Planning Supporting Statement : 23 Linksway Notthwood HA6 2XA

Proposed Revisions to Approved Plans & comments received at Pre-Application taken into account

drawing: PROPOSED ELEVATIONS

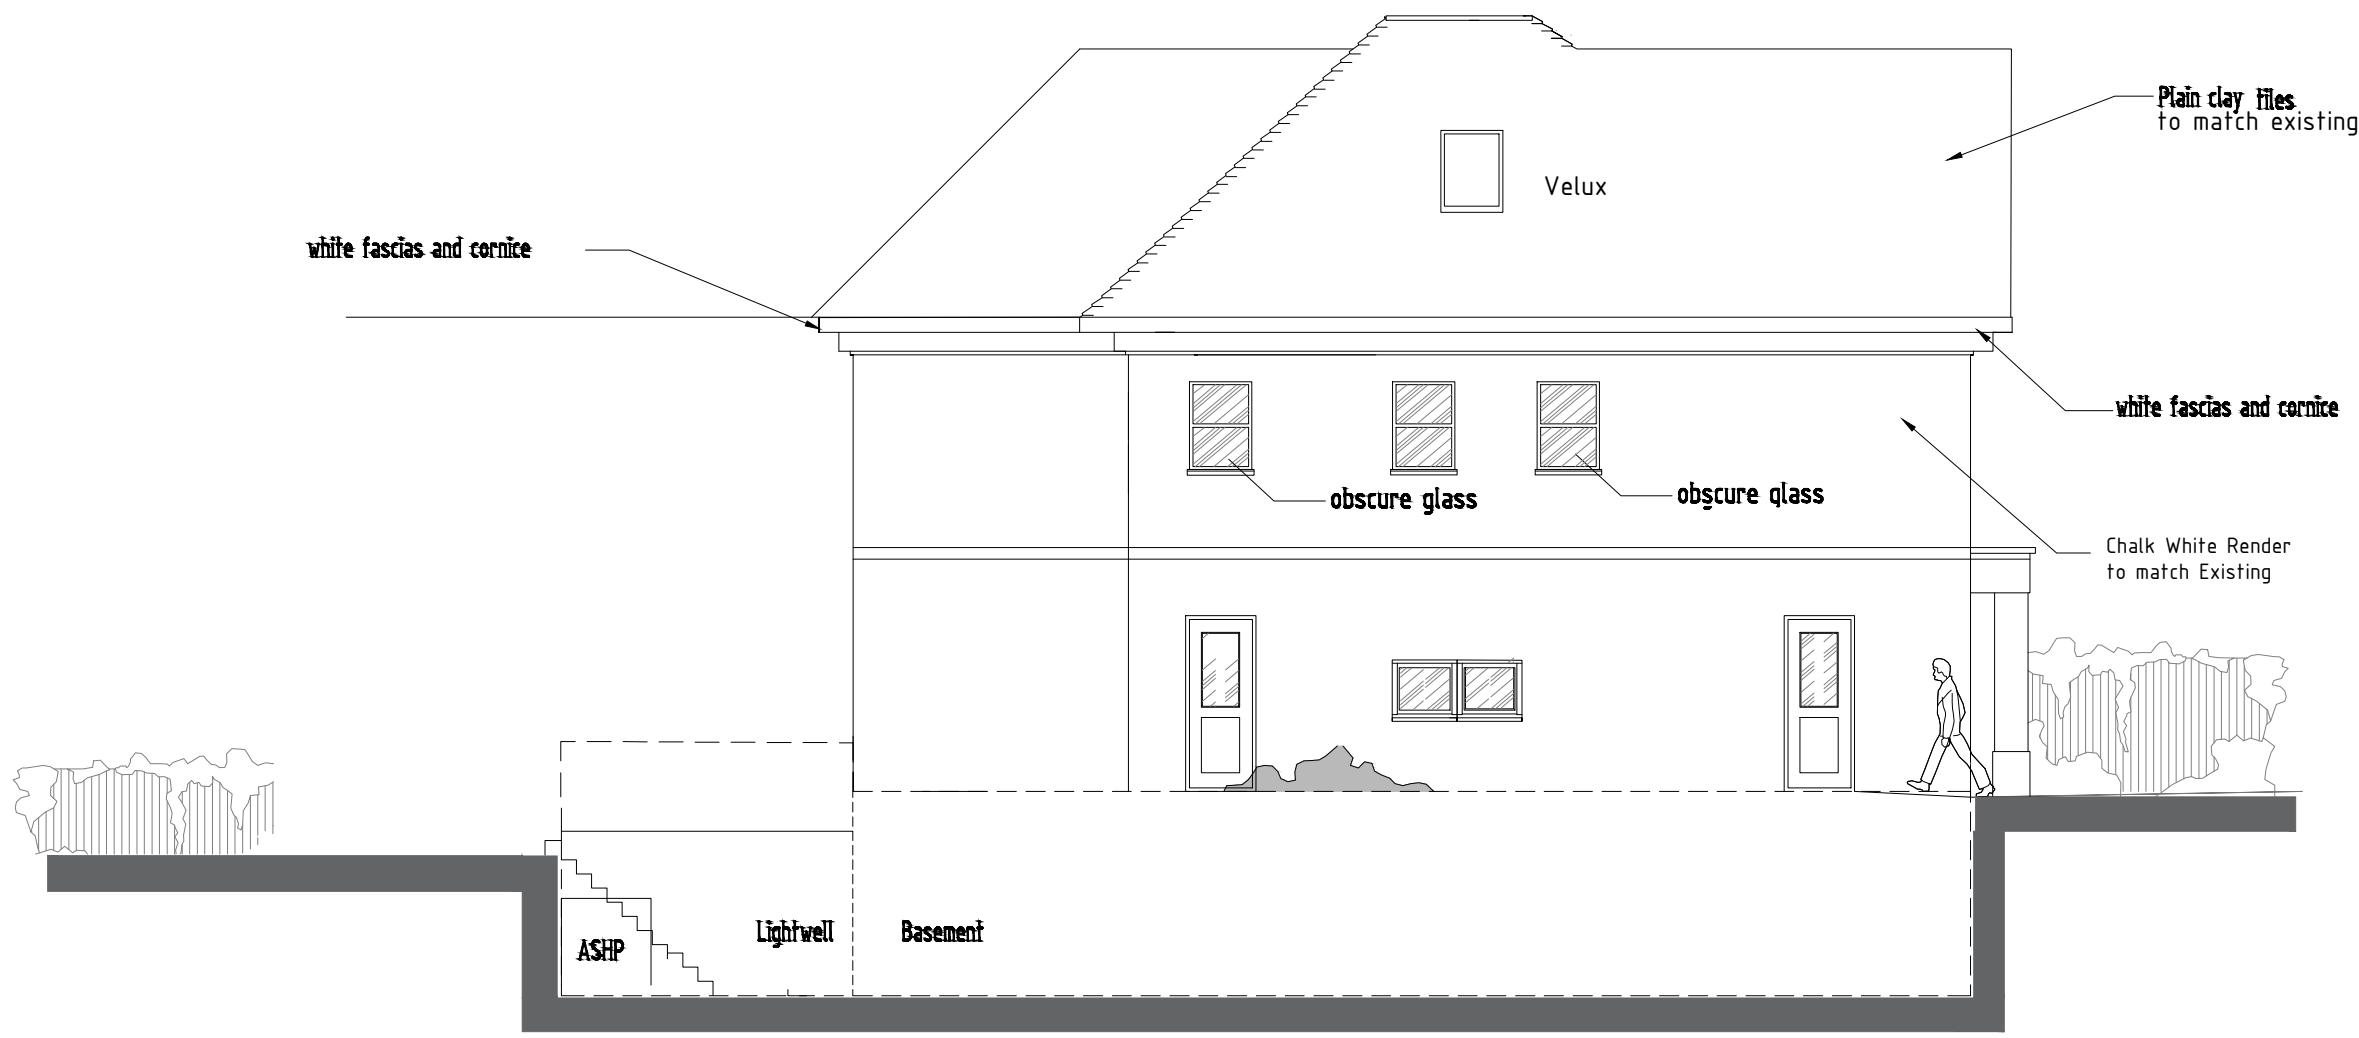
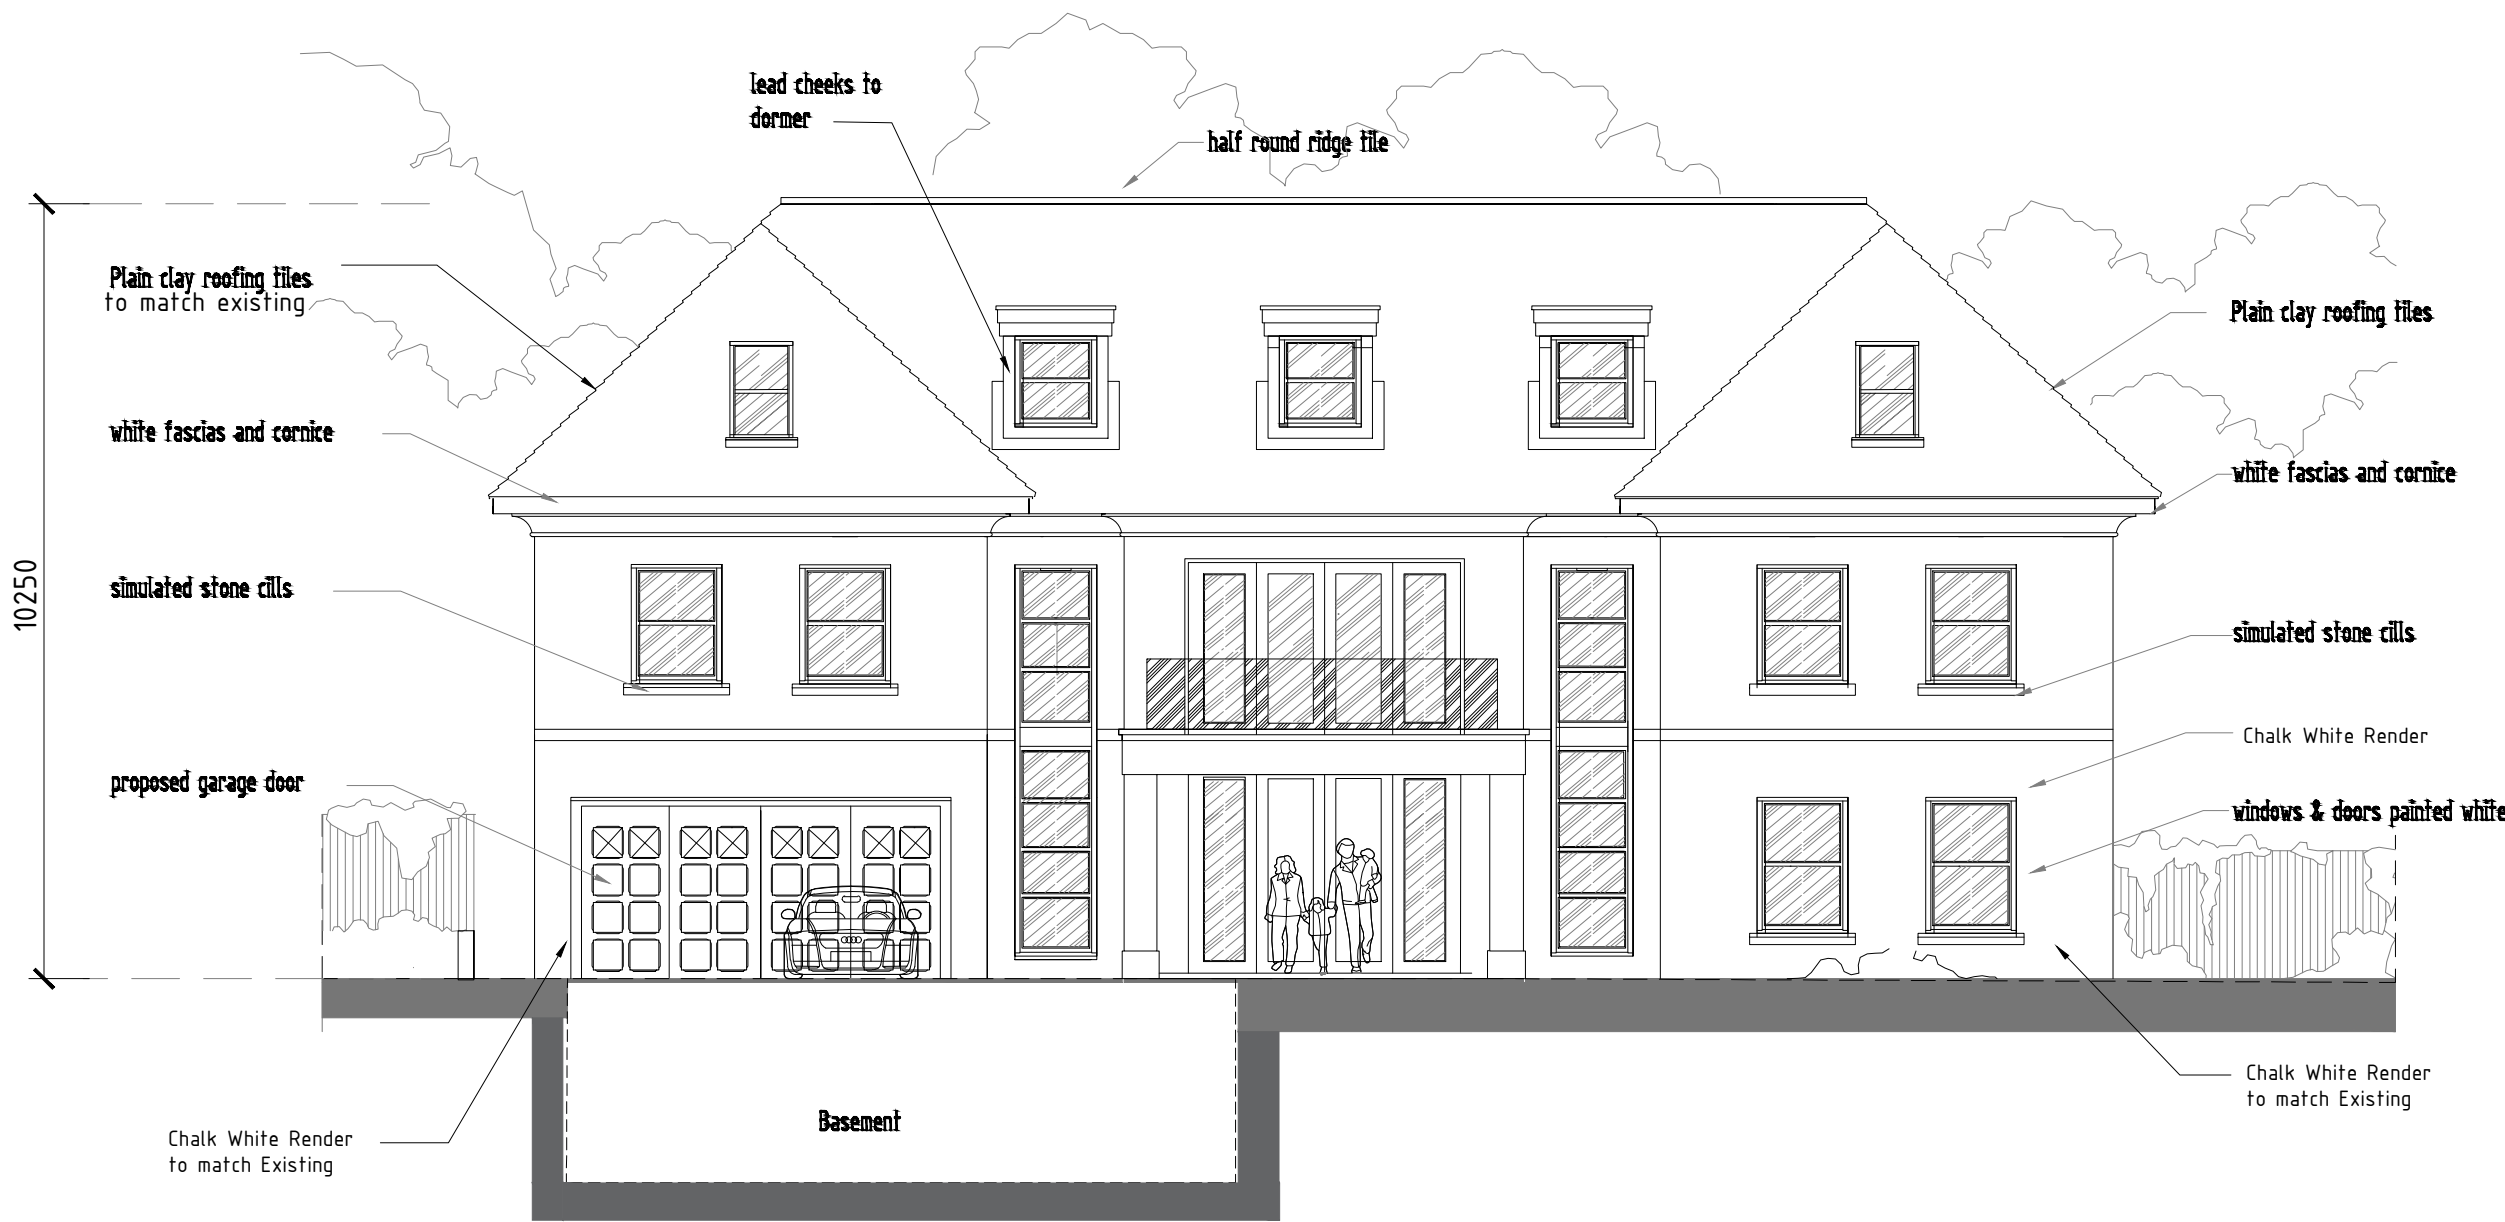
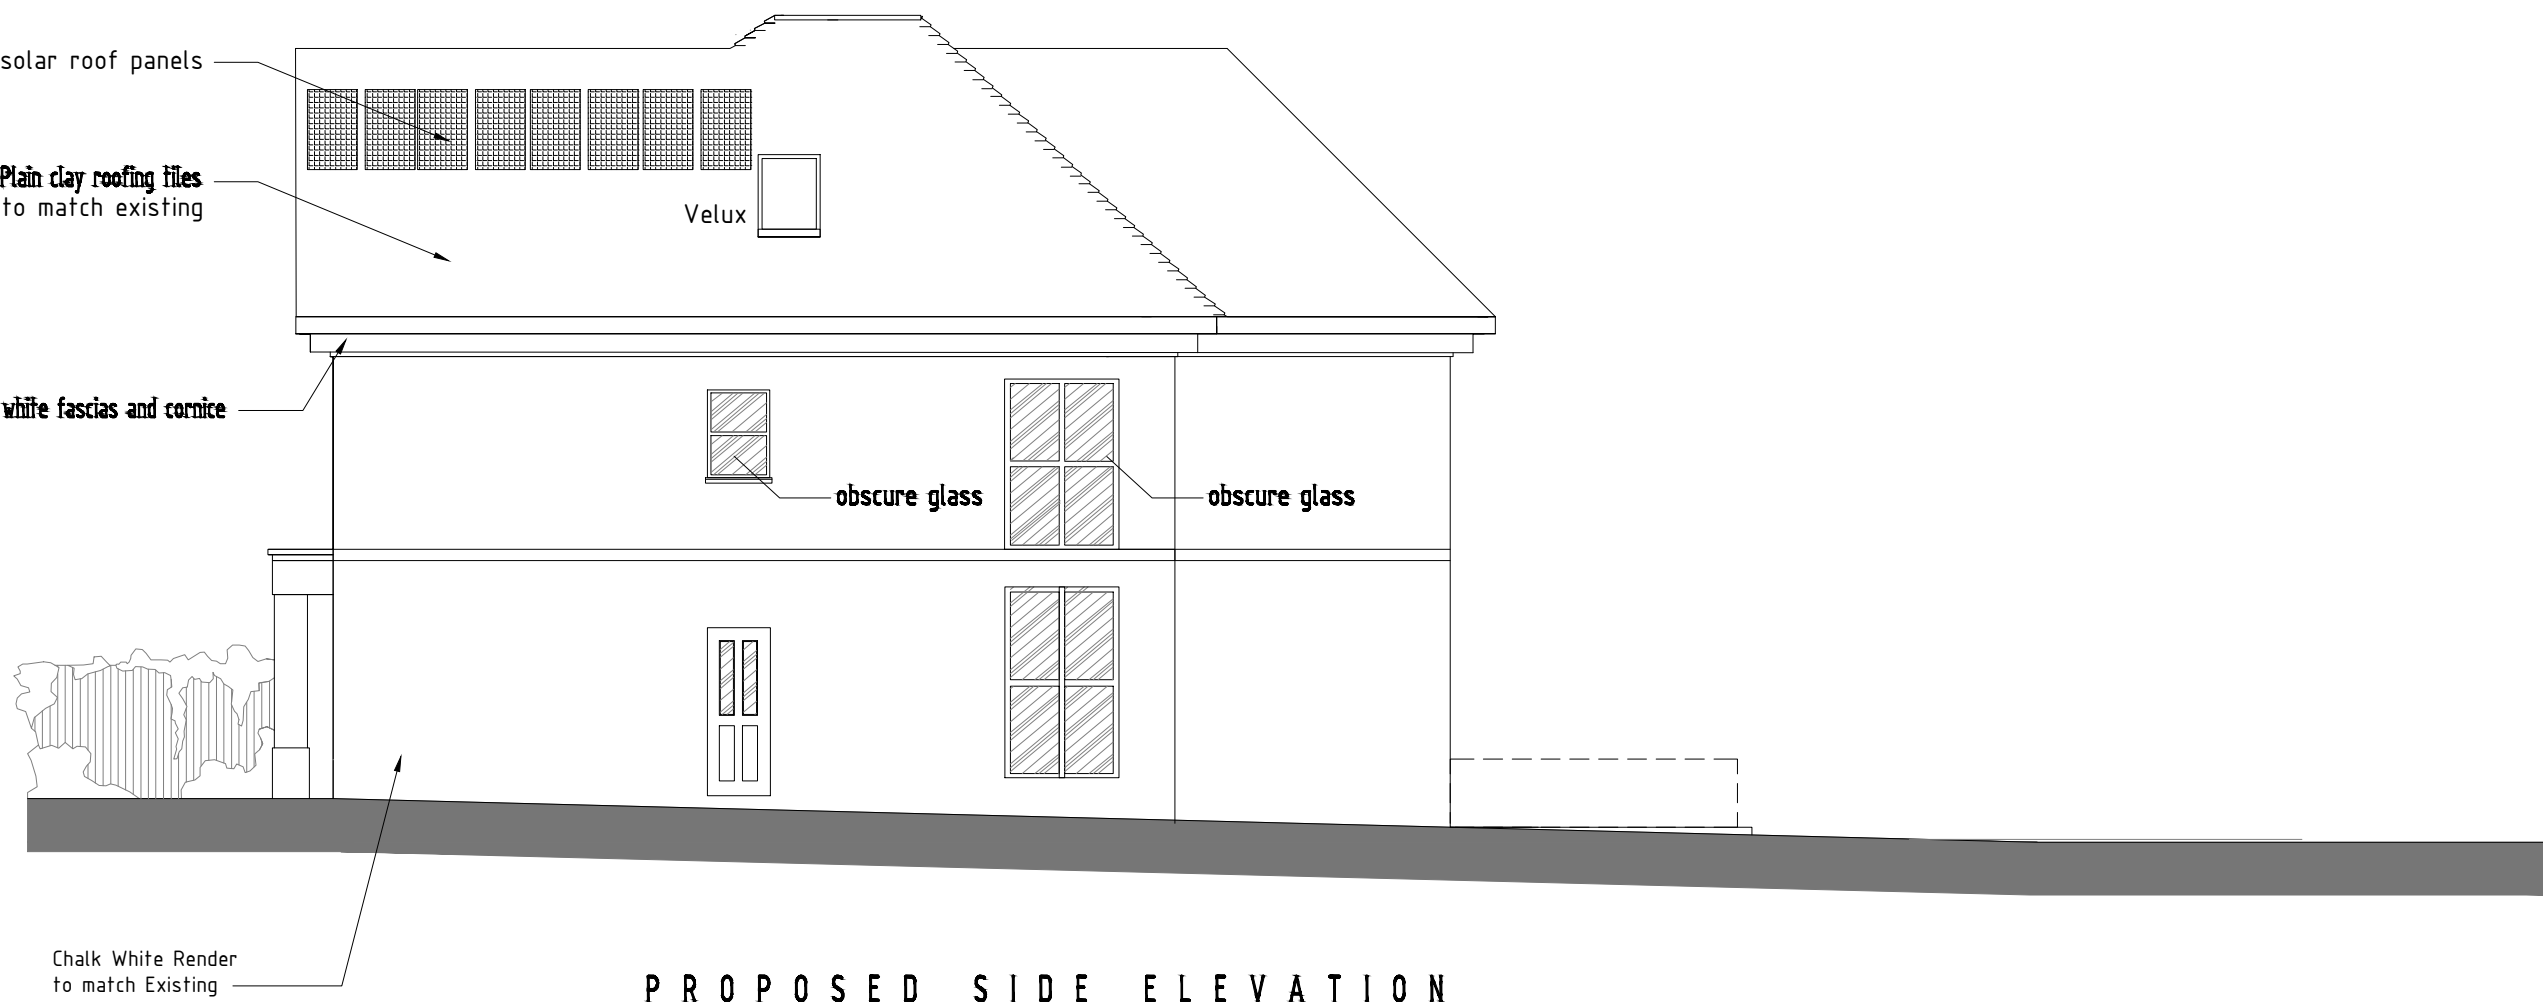
Front Elevation is replace of Brick finish back to original house chalk white render

Suggestion is to Omit Brick Finish as approved,
with white rendered similar to original house (demolished) and adjacent 25 Linksway

The 2nd aspect of Re-modelling is to have gable to the two projected wings.

1. reduce the heavy brickwork bulk that overpowering in a site that is heavy landscape site with many TPO.
2. design that articulates a softer clear elevation reduces bulk allowing the sites mature TPO landscape streetscape to prevail.

The same approach to remodel is repeated with rear elevation.

We welcomed the support in general at Pre-App meeting discuss our have taken on board the comments related to fully glazed front gable, which has now been omitted with a more traditional front gable with a small feature window that is now in keeping with the front elevation
